2012/0888

re comments from Steve Billcliffe - Pollution Control Adj. Thurnscoe WMC.

THURSDAY WORKING
MENS CLUB.

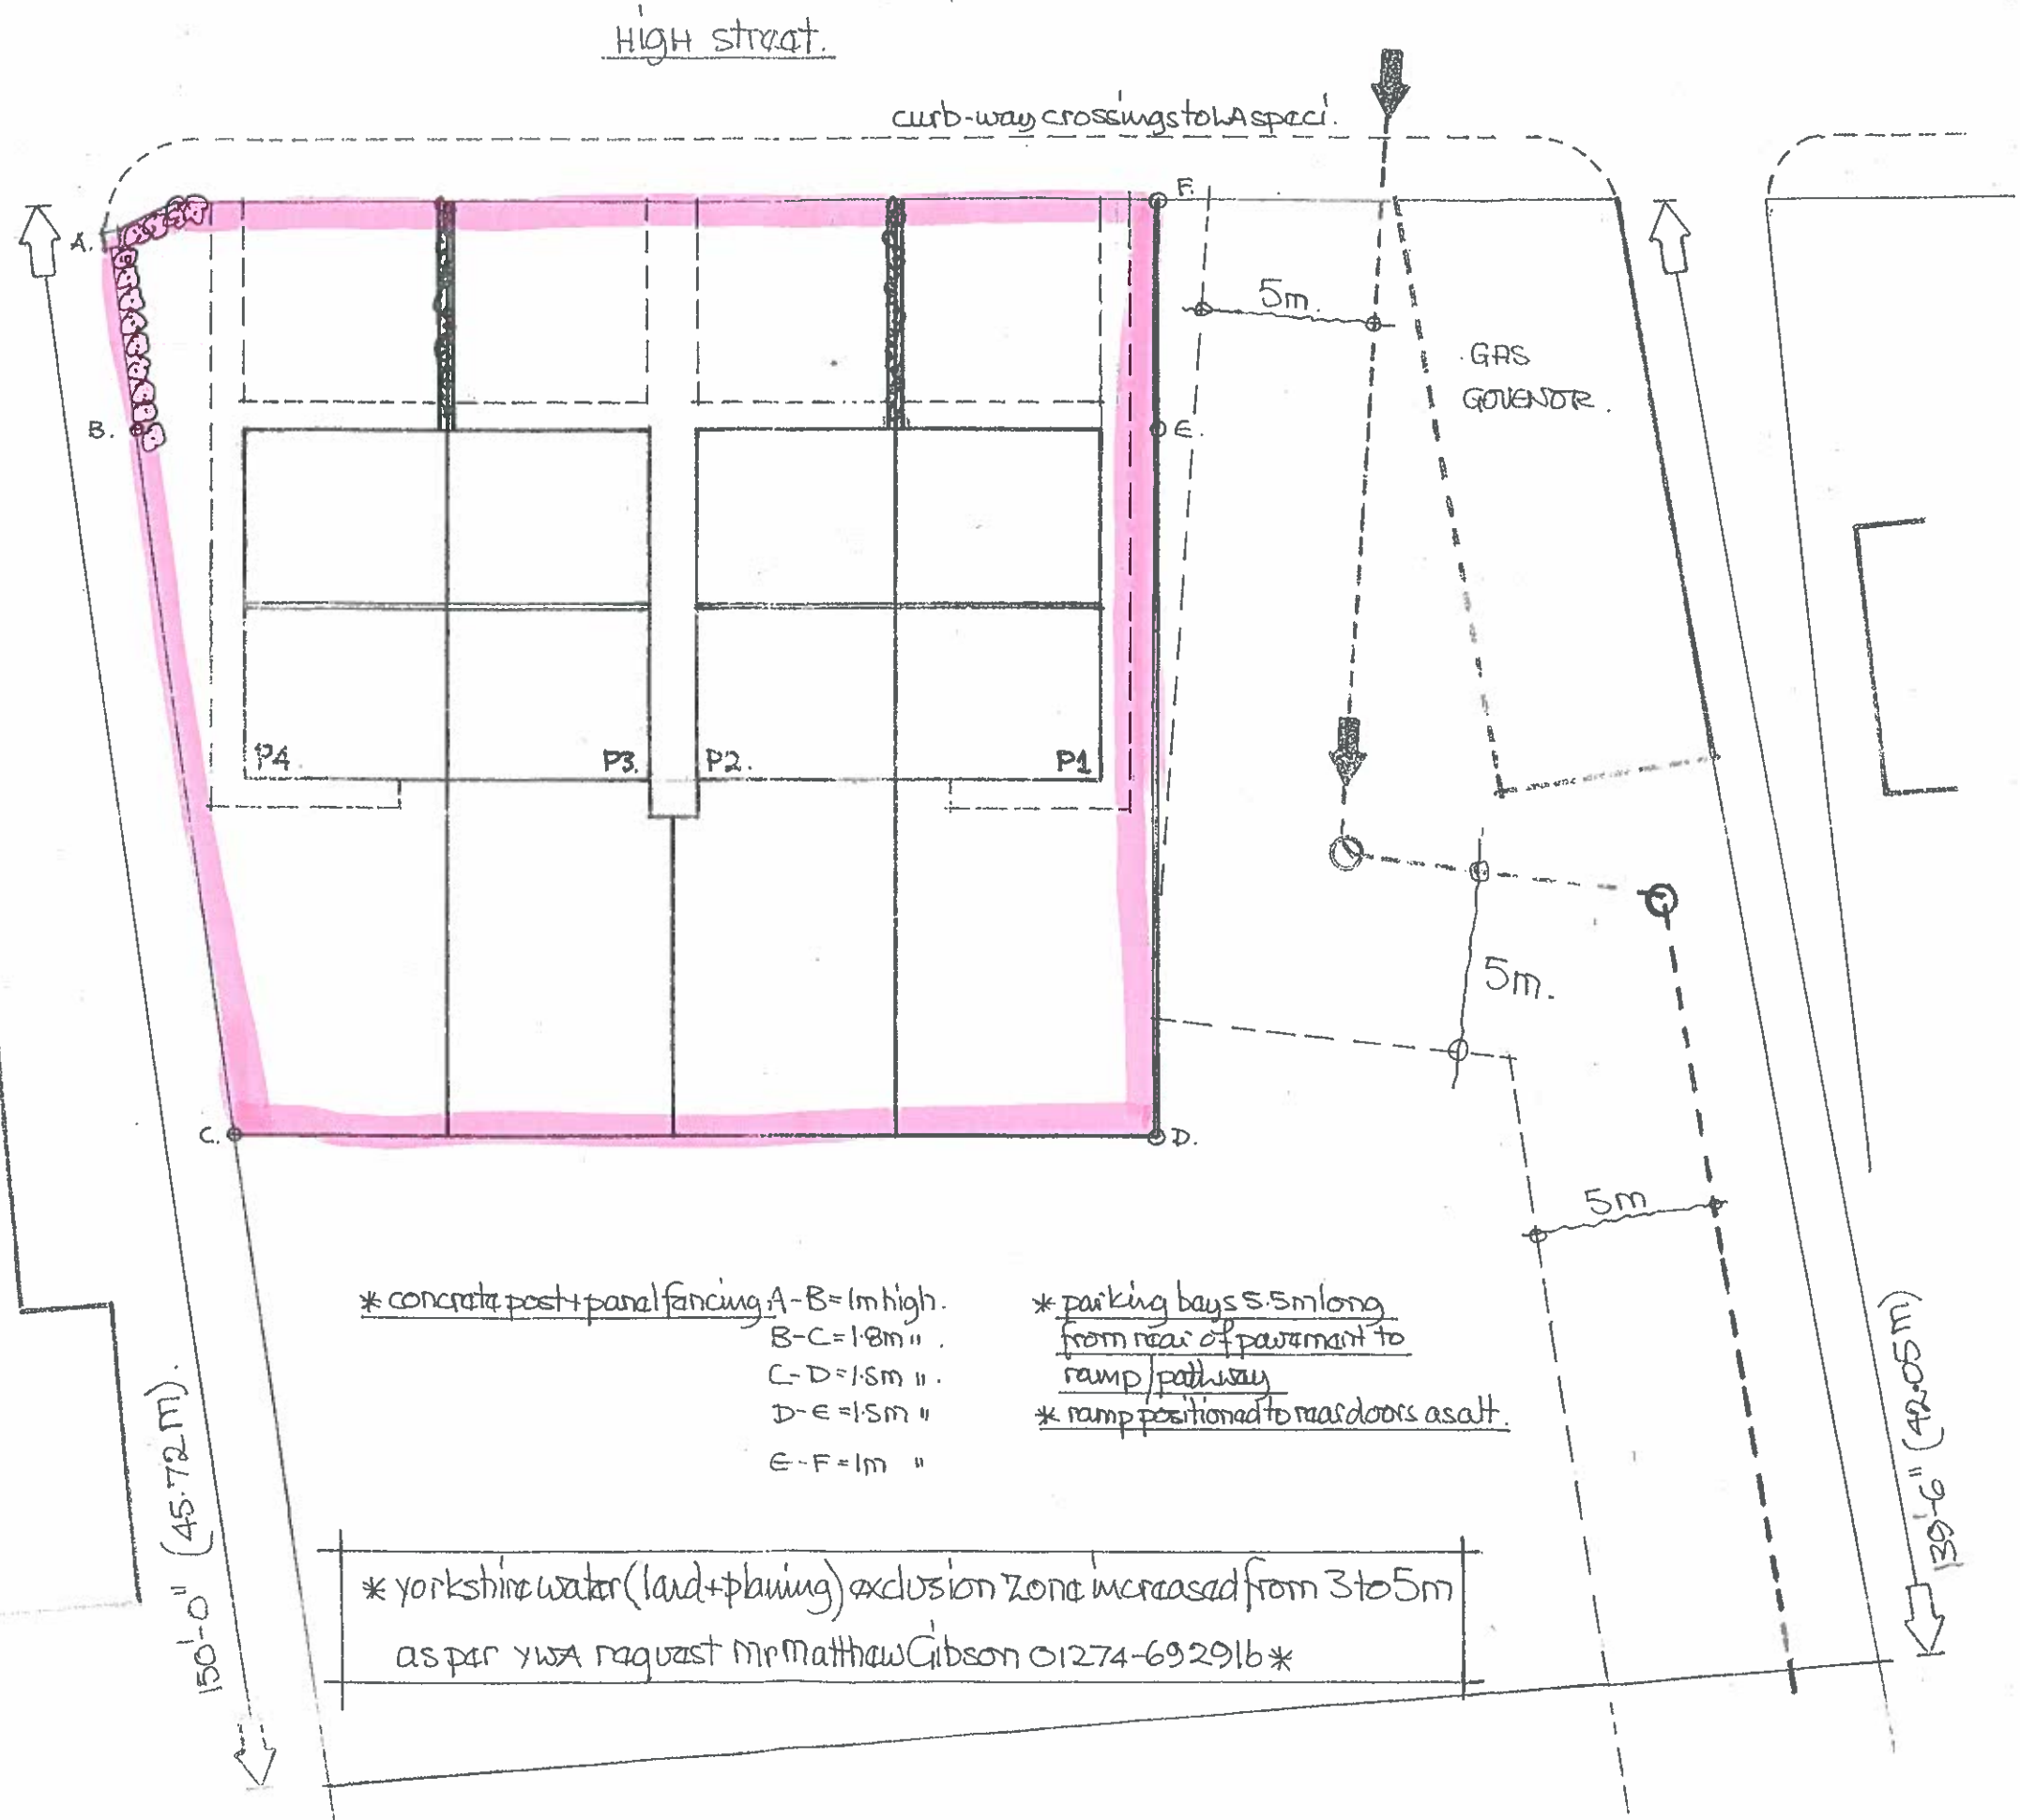
- a) the proposed dwelling plot 5 will have some 8m separation from the eastern facing elevation of the WMC.
- b) the windows within the elevation are situated within the club office & the lounge. The lounge area is a quiet area.
- c) at the front of the club a smoking area exists, the elevation of which has had timber spaced panels fitted, which will act as a natural baffle to sound, facing the gable of plot 5.
- d) the proposed fencing forming the boundary between plot 5 & the club could be increased to 1.80m.
- e) the five dwellings will have 20mm double glazing within UPVC frames.
- f) the access for vehicles to the club are situated on the club's western perimeter, from Billingley Drive.
